**Your  
Reference** SSD-35609161

**Our  
Reference** NCA/6/2022

30 August 2022

**City of Parramatta Council submission to State Significant Development Application for a mixed-use building, including 'Build to Rent' units at 12 Hassall Street, Parramatta**

Title
B-GENERAL ARRANGEMENT PLANS
BASEMENT LEVEL 3 FLOOR PLAN

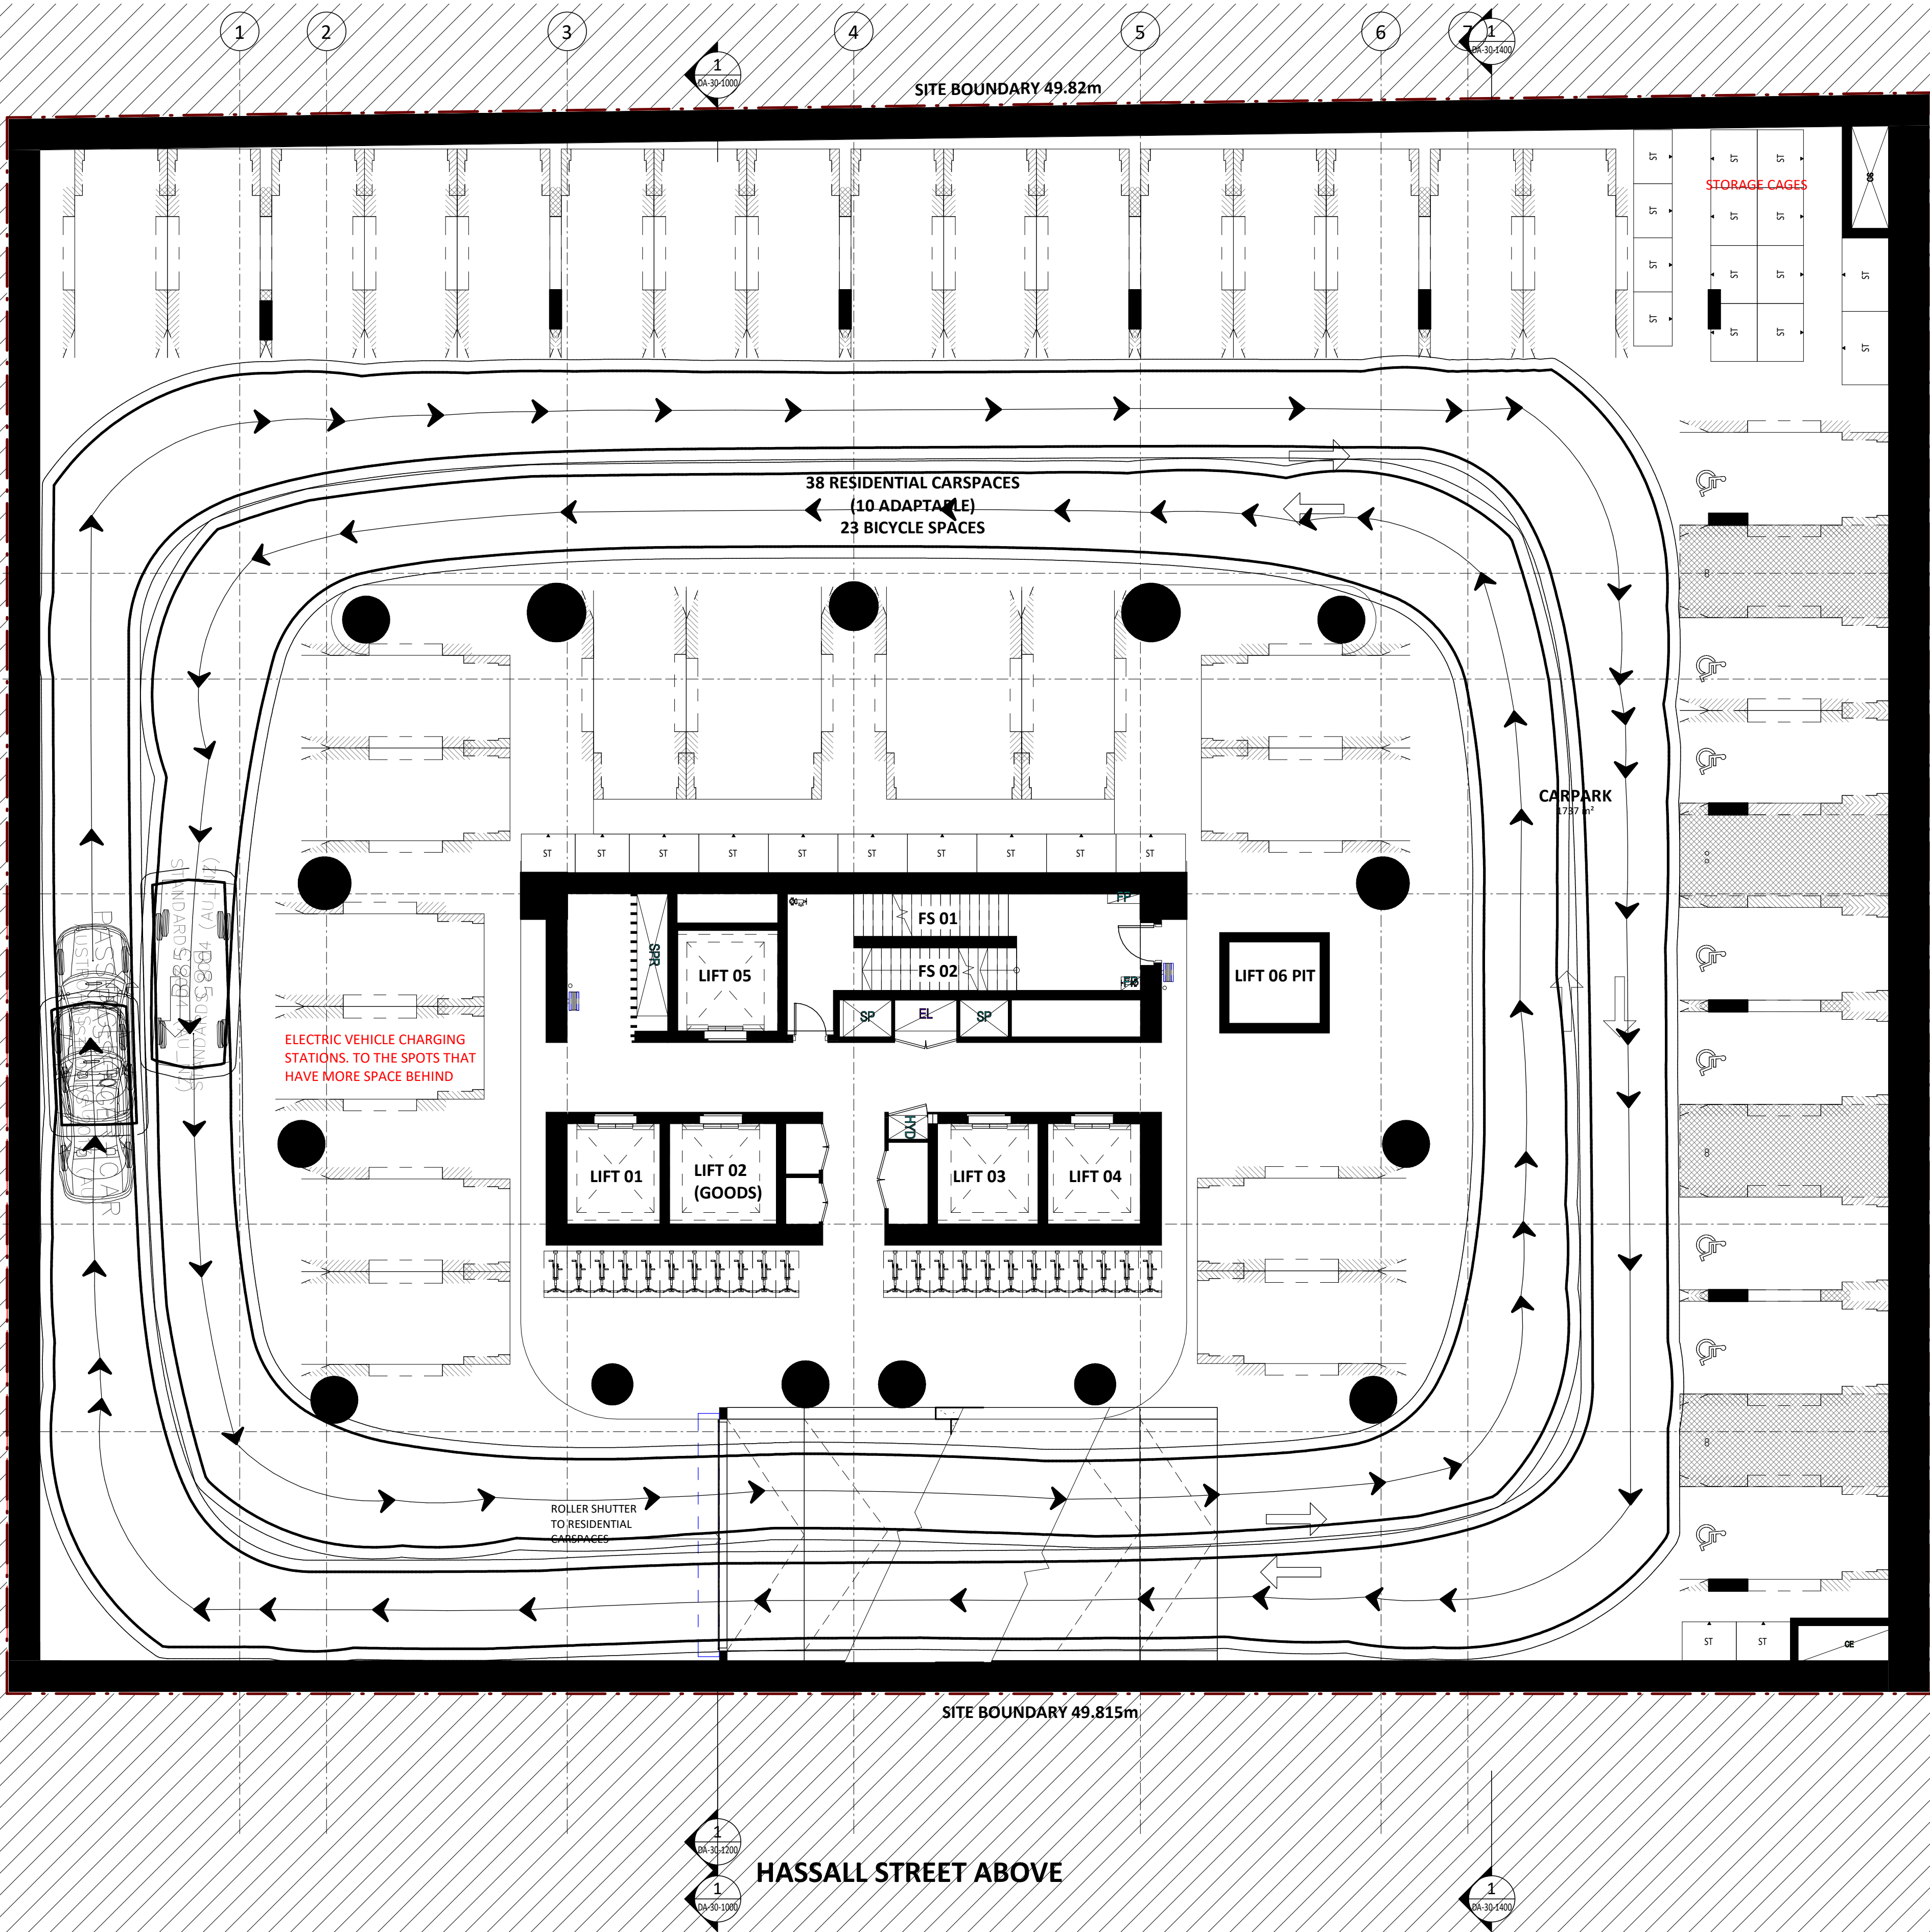
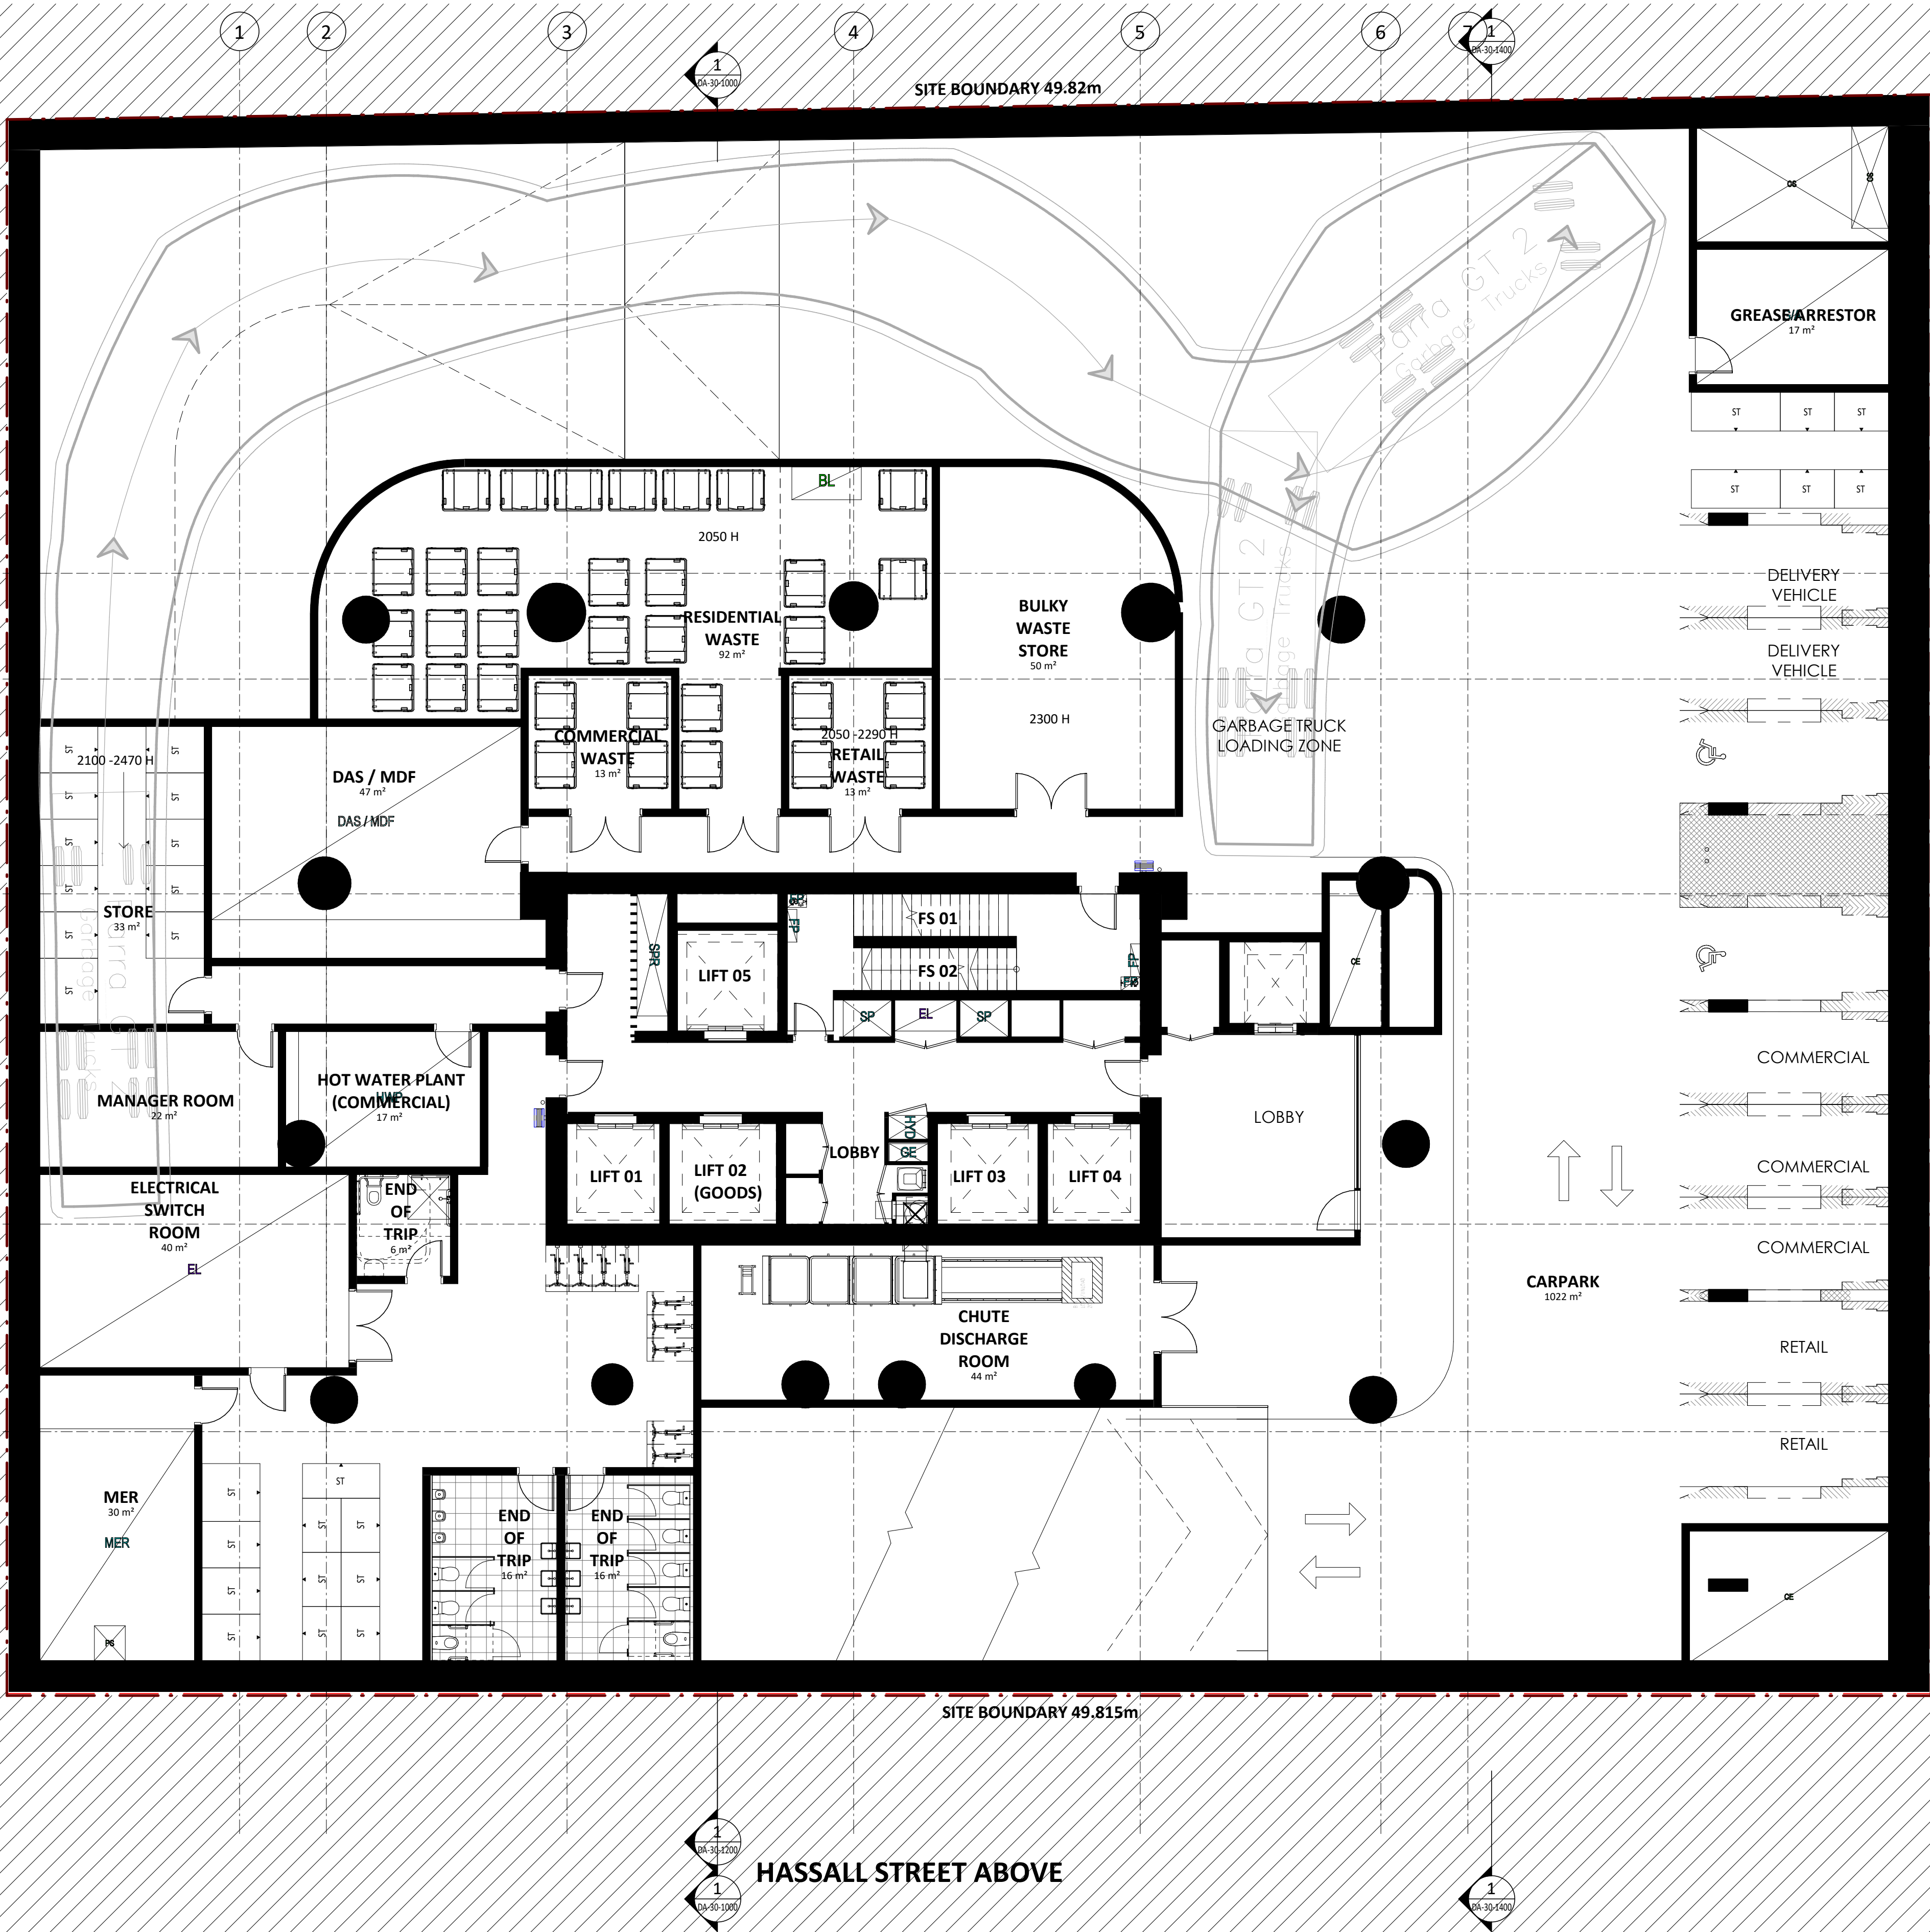
The basement plans should be amended to include the provision of lockers to support the end of trip facilities as per the requirements of Amendment 56 of the Parramatta LEP 2011.
